**National Infrastructure Project Section 42 Planning Act 2008 Response
by Blaby District Council**

Hinckley National Rail Freight Interchange

Junction 2 of the M69, Leicestershire

April 2022

Map 4.2: Location plan of the seven potential SRFI locations appraised by the Applicant

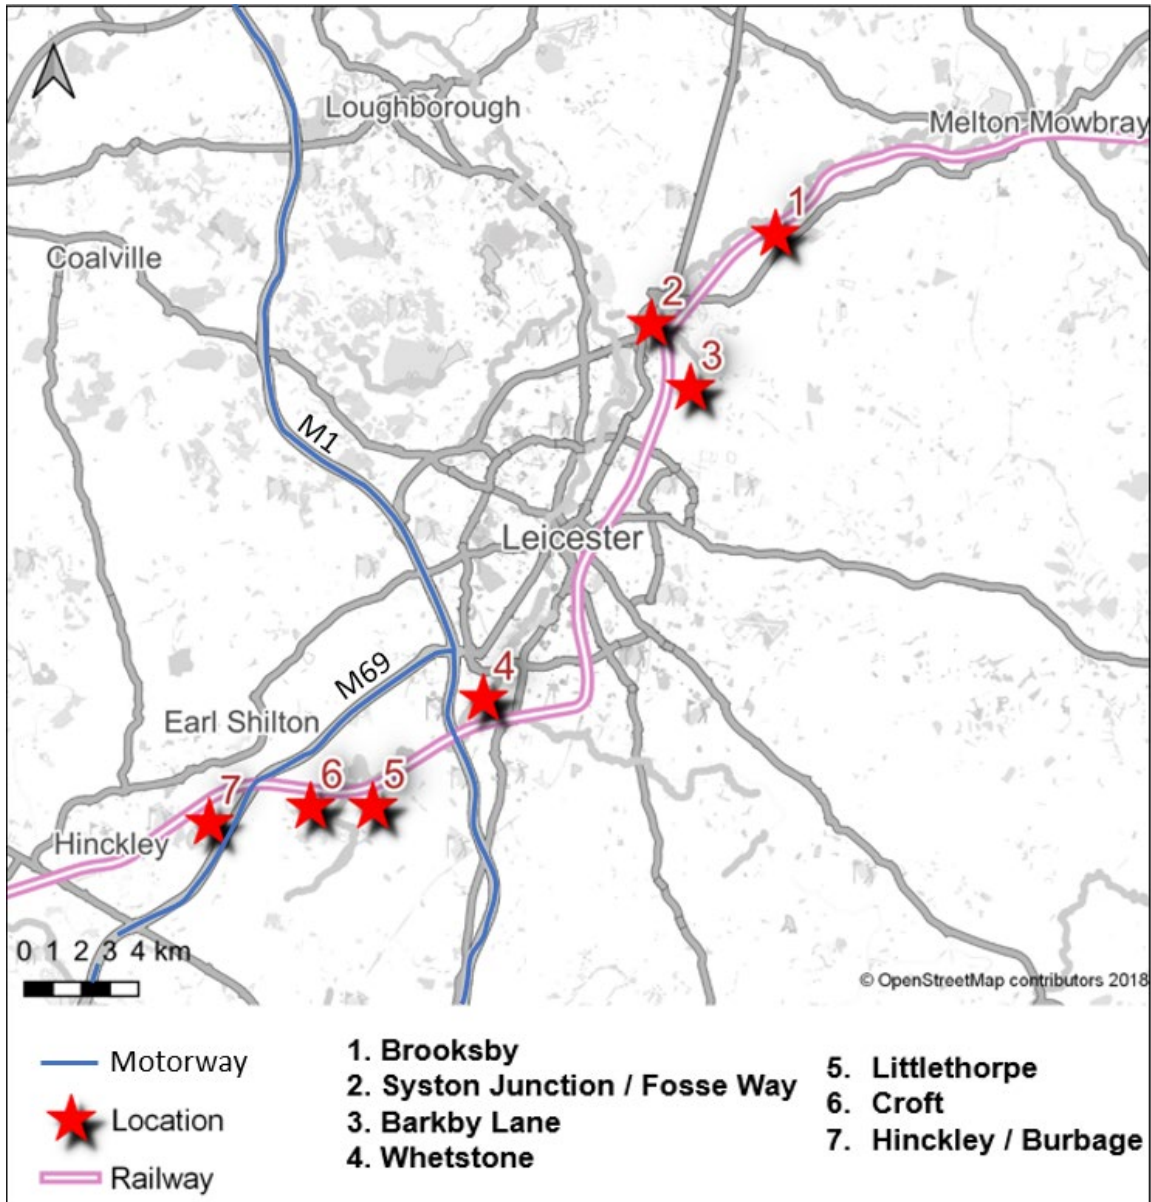
Ref.	S42 Response Comment
Chapter 4 Selection and Evolution NEGATIVE	
Para 4.15	Agree with criteria and principles used in assessing location options.
Paras 4.17 – 4.63; Map 4.2	Question the relevance of site options 1 – 3 (Brooksby, Syston Fosse Way Junction and Syston Barkby Lane) as these are all located to the north-east of Leicester. Whilst located on the same freight line, they do

<p>not accord locationally with the <i>Leicester and Leicestershire Enterprise Partnership's Strategic Economic Plan 2014-20</i> (March 2014) growth area option of 'South West Leicestershire' (Option 5) to which this proposal has been grounded within paragraph 4.6 of the HEIR. These options also do not correlate with the more recent Leicester and Leicestershire Authorities Warehousing and Logistics in Leicester and Leicestershire: Managing growth and change (April 2021) with Area of Opportunity 1 identified as between Leicester and Hinckley (paragraph 11.8 and figure 15). If 3 of the 7 sites assessed do not fall within the perceived area for growth then these cannot realistically be considered feasible alternatives.</p>
<p>Paras 4.32 – 4.41; Map 4.4</p>	<p>Notwithstanding the above comment, the Syston Fosse Way Junction site was discounted largely as it was within the floodplain. Although the exact site search area is not shown, it appears to clearly relate to land between the A46, Railway line and the Fosse Way. However land theoretically also appears accessible to the north of the A607 junction with the A46, and to the west of the A46. Neither option appears to have been considered.</p>

<p>Map 4.2</p>	<p>Question whether all alternative sites have been explored. There is potential on the extensive tracks of land to the north of Stoney Stanton; and scope to position between Hinckley and Nuneaton to the south of the A5. It is questioned whether the current alternative assessment options accords with the requirements of the NPS paragraphs 4.26 – 4.27.</p>
<p>Para 4.130 (i)</p>	<p>The ability to increase the number of rail-connected units through provision of a central railport is not considered to have been fully considered:</p> <p>The site is repeatedly referenced as being level, so to suggest here that its gradient does not permit a central railport is contrary to the position set out elsewhere in the PEIR. Whilst the current aim is to provide two plateaus of land, this could be provided as a single level area.</p> <p>It is possible to design the site so that buildings are positioned either side of the railport, with highway access on the opposite sides. The quantum of building footprint may however be lower, but functionality and the ability to appropriately mitigate it should take precedence over the quantum of development. This is the approach that has been taken forward at East Midlands Gateway. If such a solution cannot be delivered here, then perhaps the site is either overly constrained and/or not suitable for the development proposed.</p>
